RE: RESPONSE TO AGENCY RECOMMENDATIONS FOR DEVELOPMENT APPLICATION SSD - 13855453

We are writing with respect to SSD 13855453 concerning the proposed Grenfell Poultry Breeder Farm. As requested on 9 February 2022, please find outlined below a response to the matters raised by DPIE and other agencies following their initial assessment of the submitted application. This correspondence has been prepared to provide a consolidated response to all matters raised by each department.

<b>Description:</b> Farms 1, 2 & 3 site plan	Prepared by: David Donaldson
<b>Project:</b> 4 x 10 x Shed Farms 1,2,3 & 4	<b>Date:</b> 8th March 2022
<b>Client:</b>	<b>Scale:</b> 1 : 600
<b>Baiada Poultry Pty Limited</b>	<b>Revision No:</b>
	<b>Drawn:</b> Drawing number:
	<b>DD</b> 1 of 6

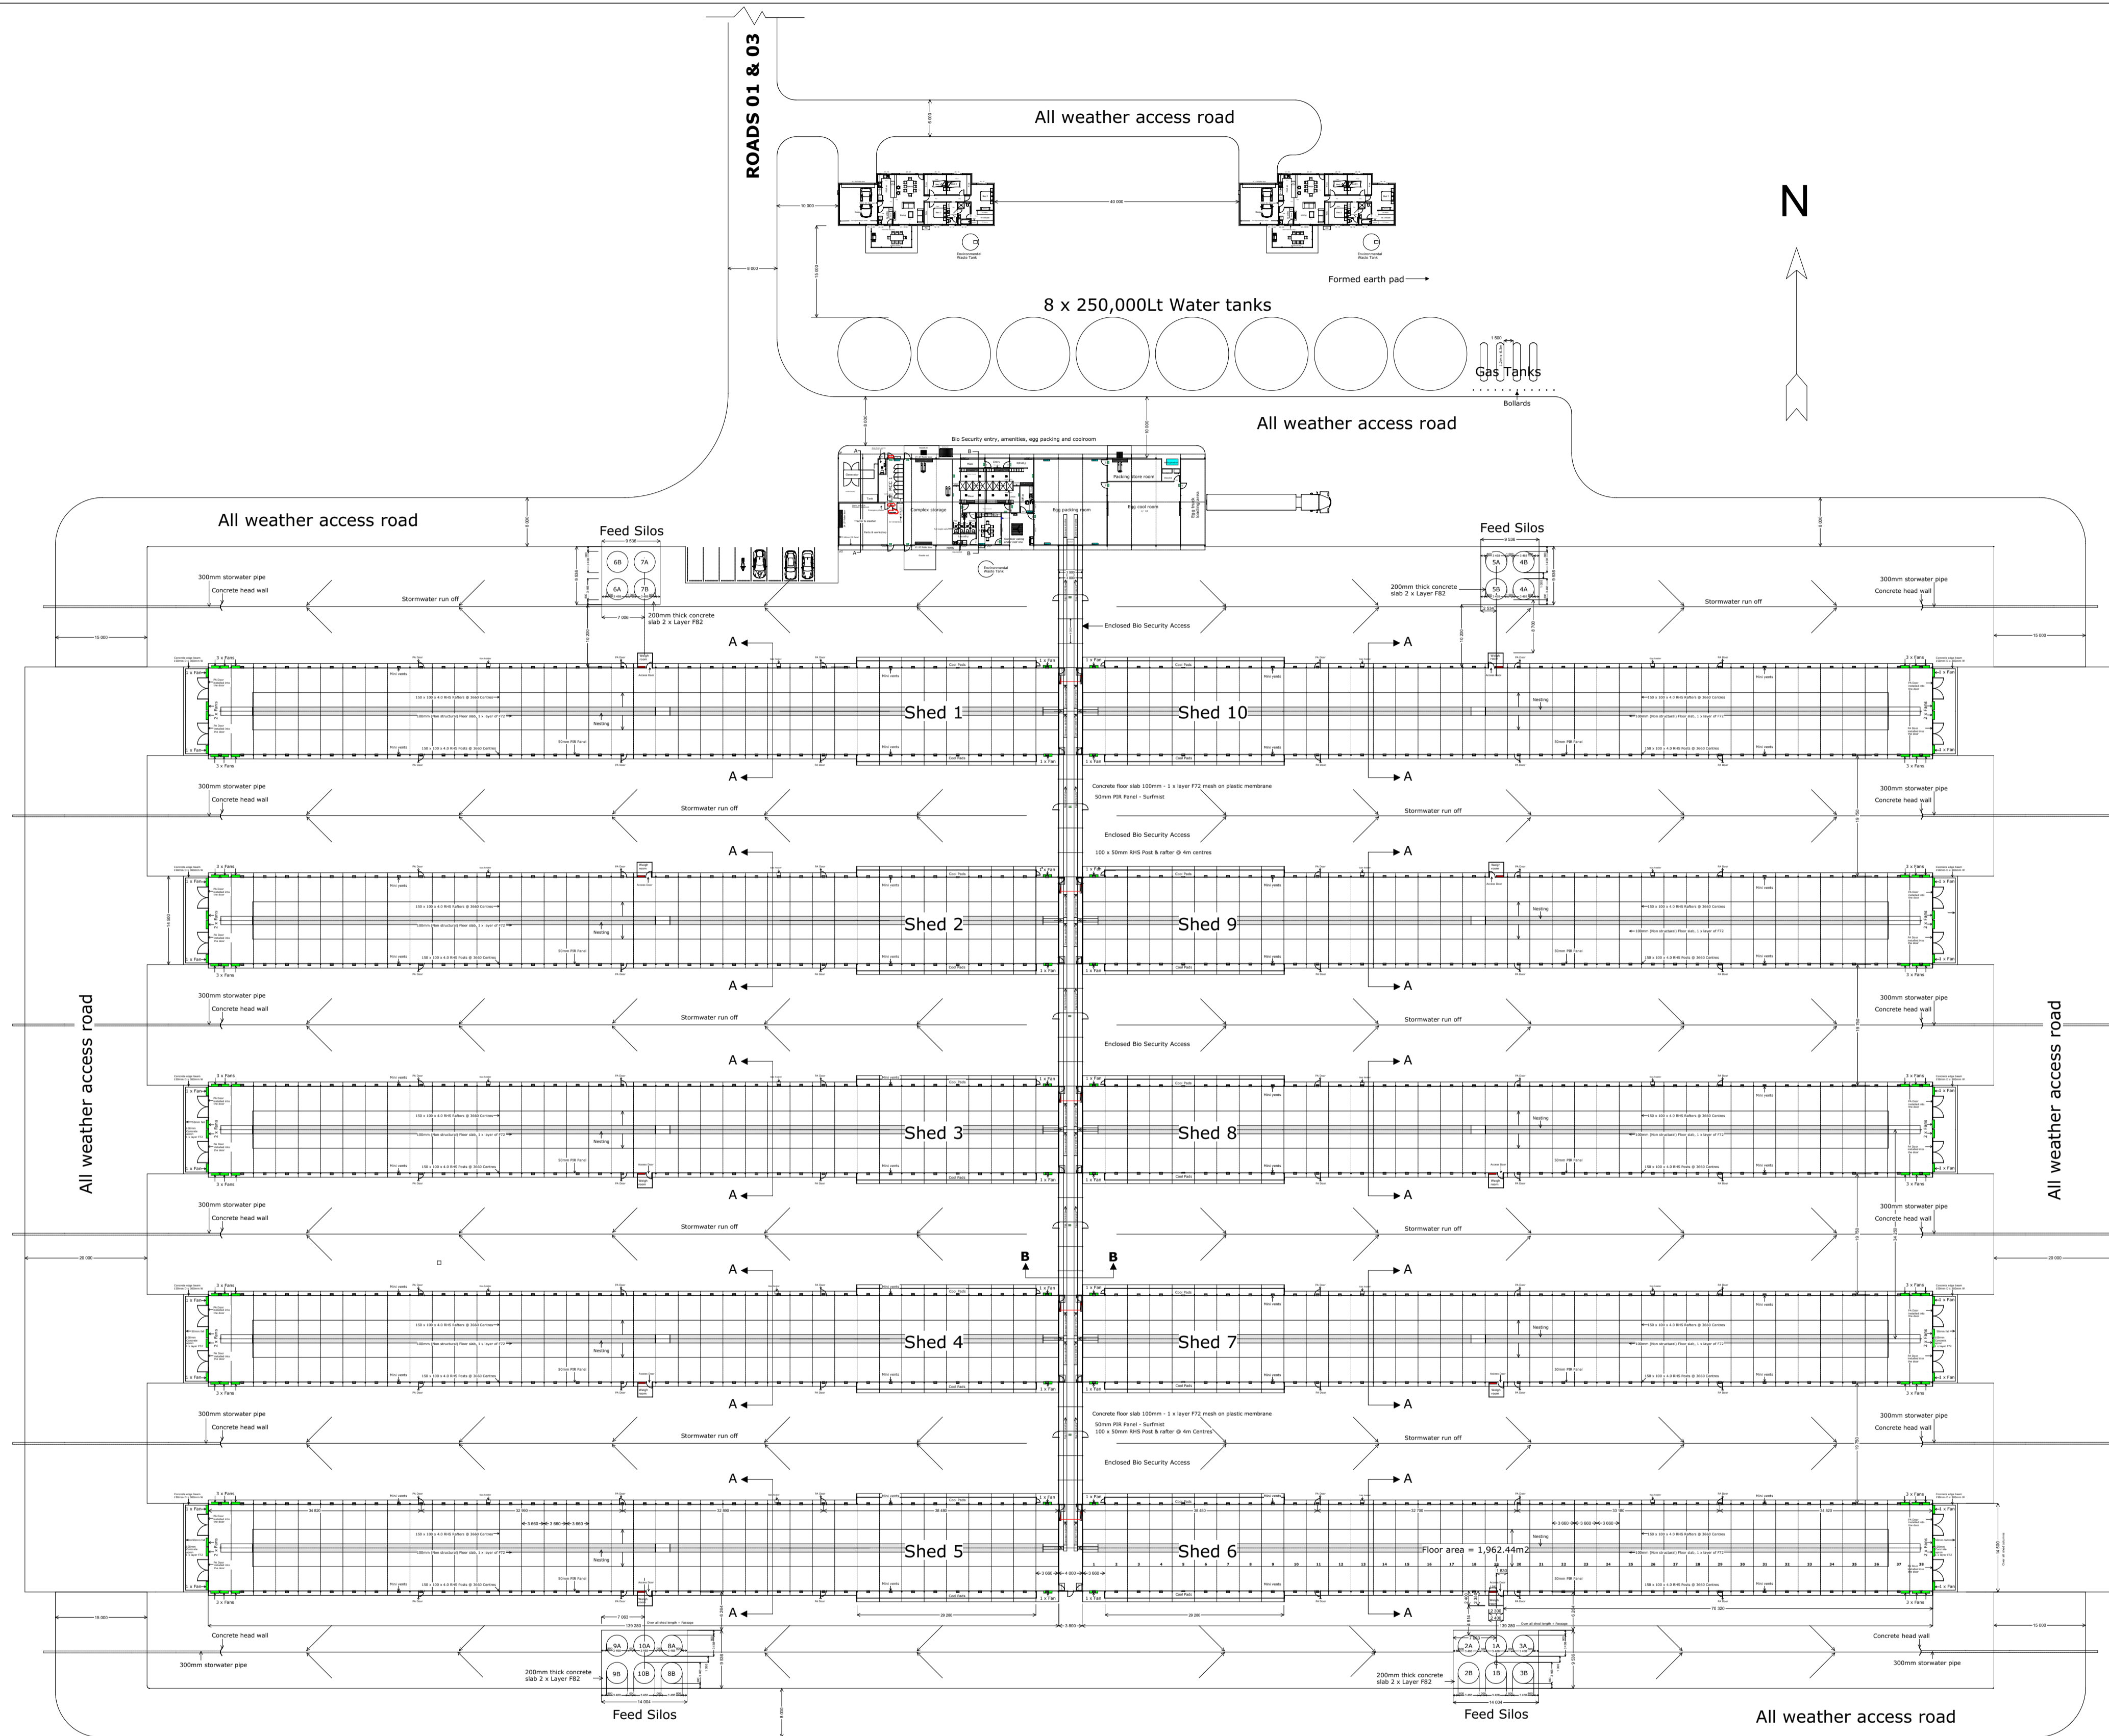
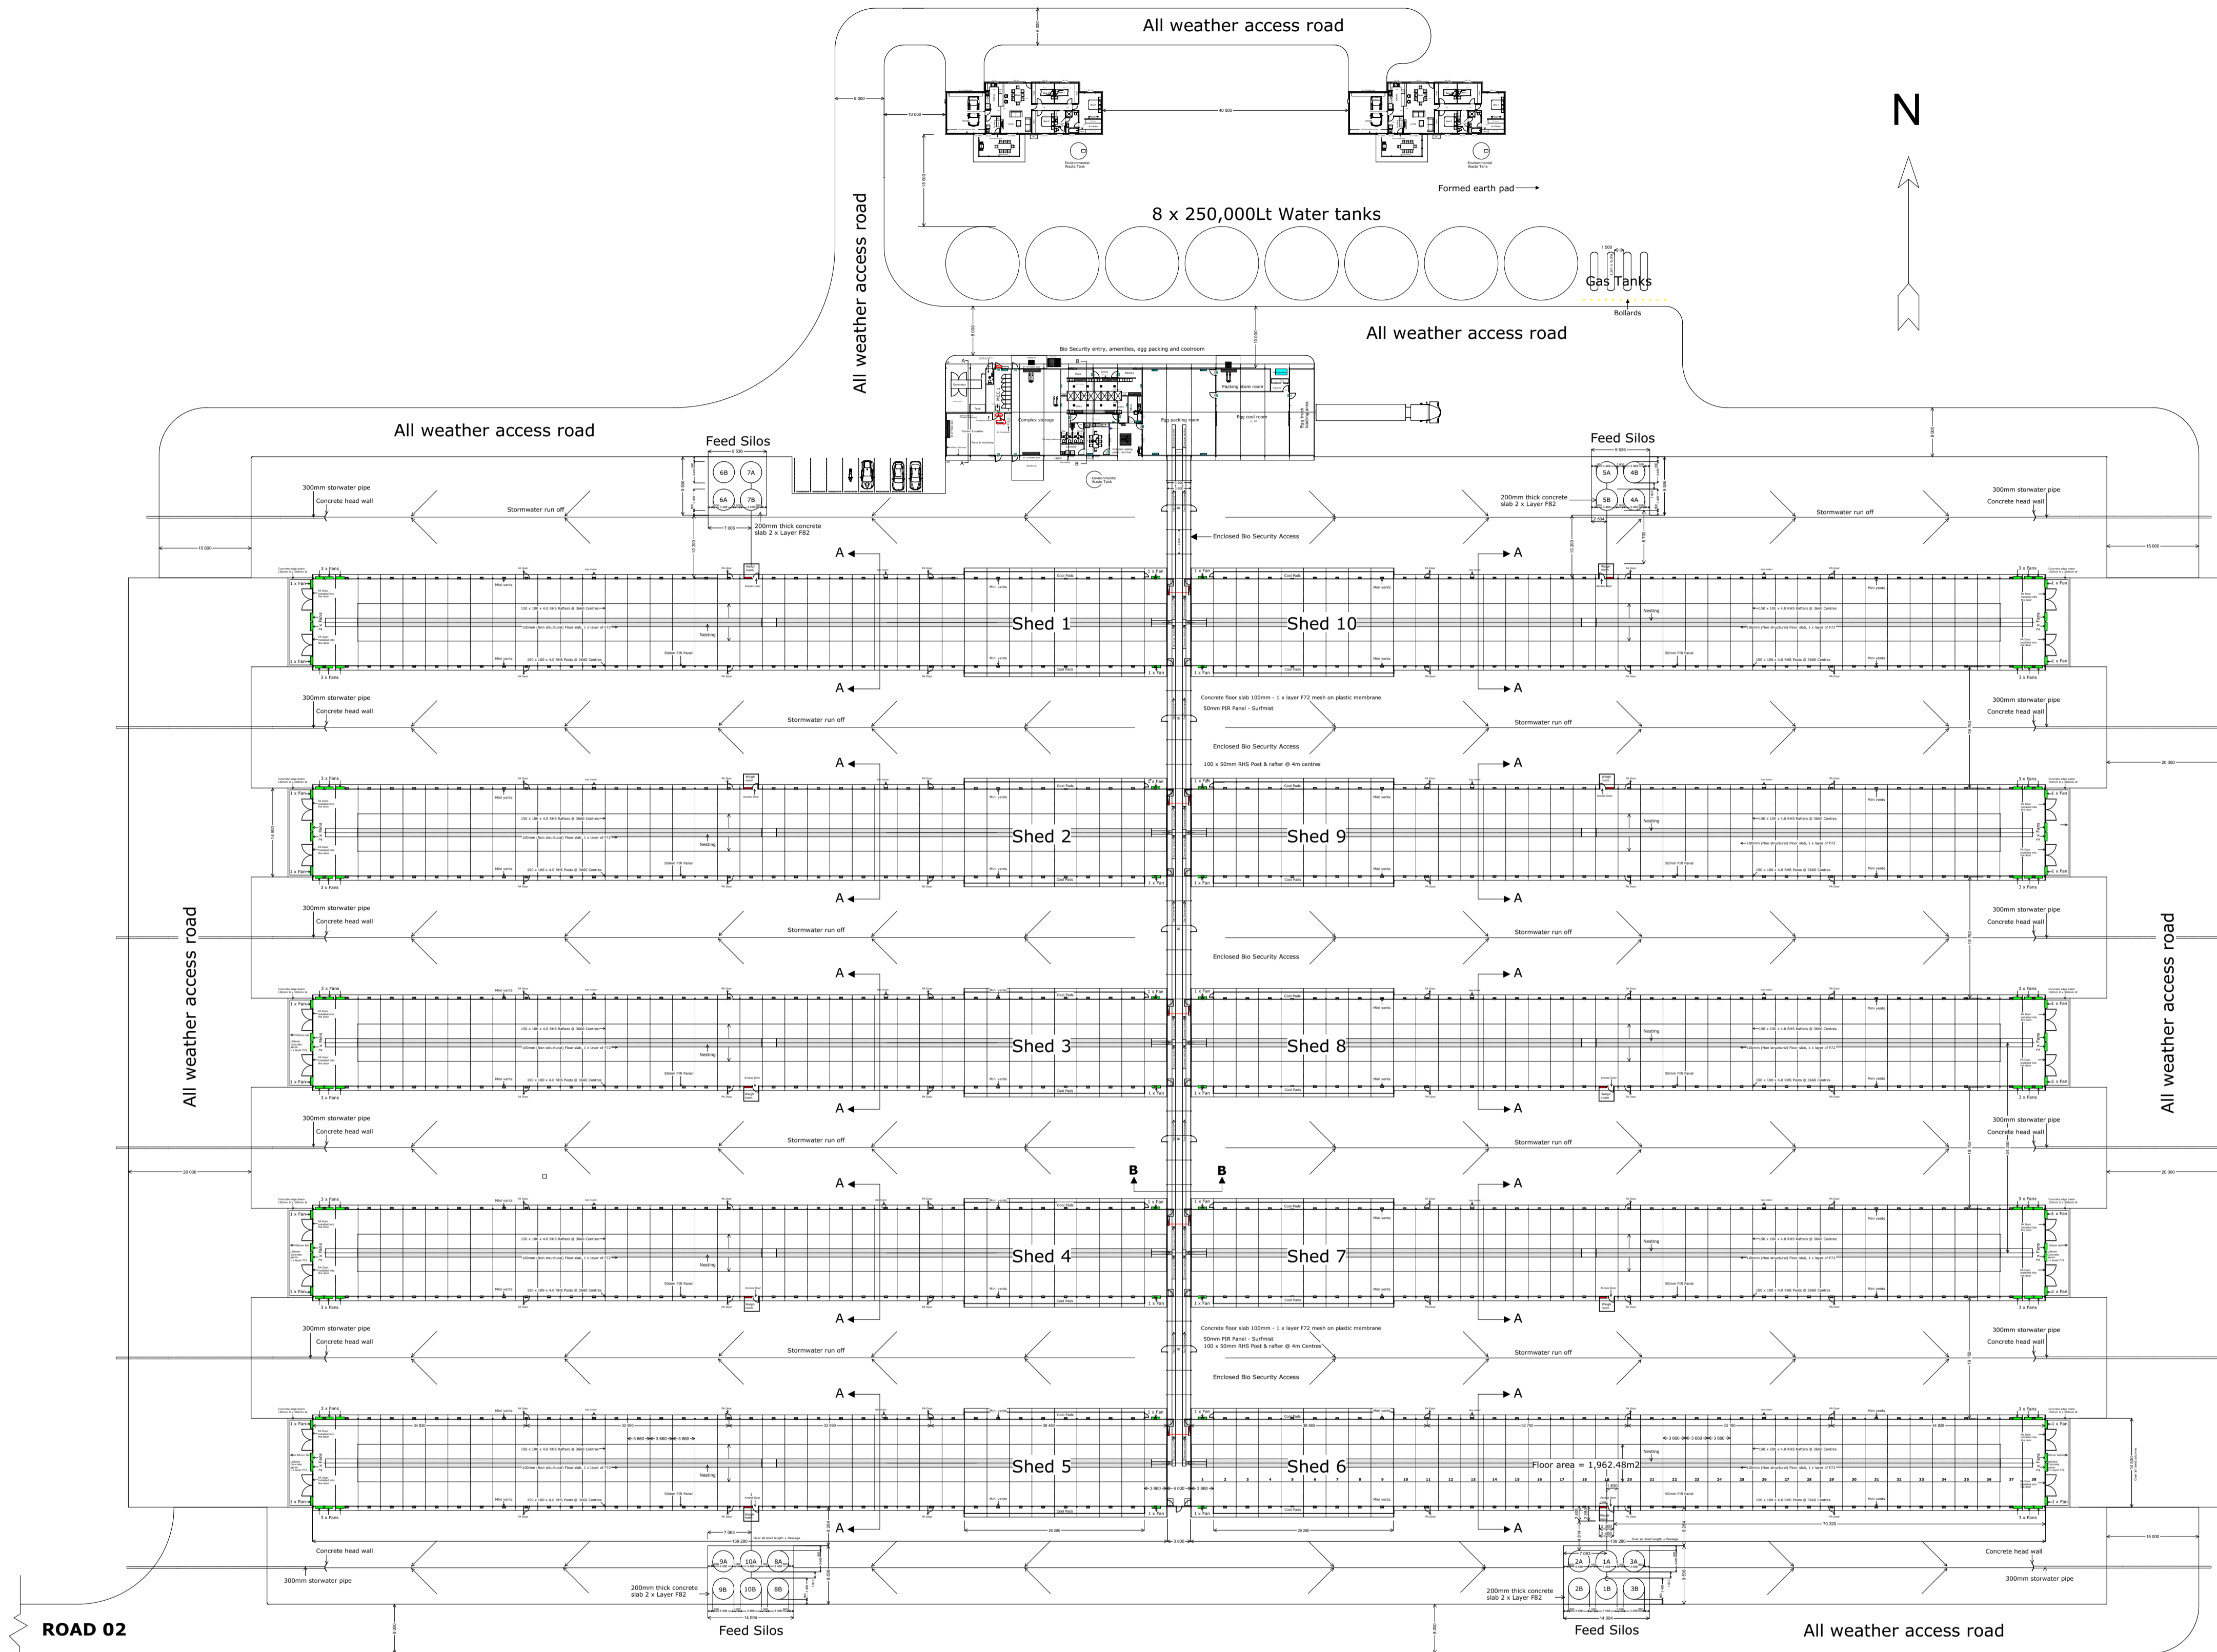
Please note that, in response to ongoing detailed design processes, minor changes to the farm site plans have been incorporated and a revised set is included as **Attachment 1** of this response. These changes include:

- All farms have now adopted a consistent site layout, including the location of the two manager residences.
- The egg packing / coolroom building has been merged with the amenities building which has also enabled the removal of one linked passageway. These changes have decreased the width (North – South) of each farm by 35.5m (i.e. a reduction of 14.5m associated with the egg packing room and 21.0m associated with the linked passage).
- Hard stand areas at both the western and eastern areas of the farms has been reduced by 5m (10m reduction in total).
- The water storage tanks are now placed in a single row instead of two, which has also reduced the overall complex width by a further 13.5m.
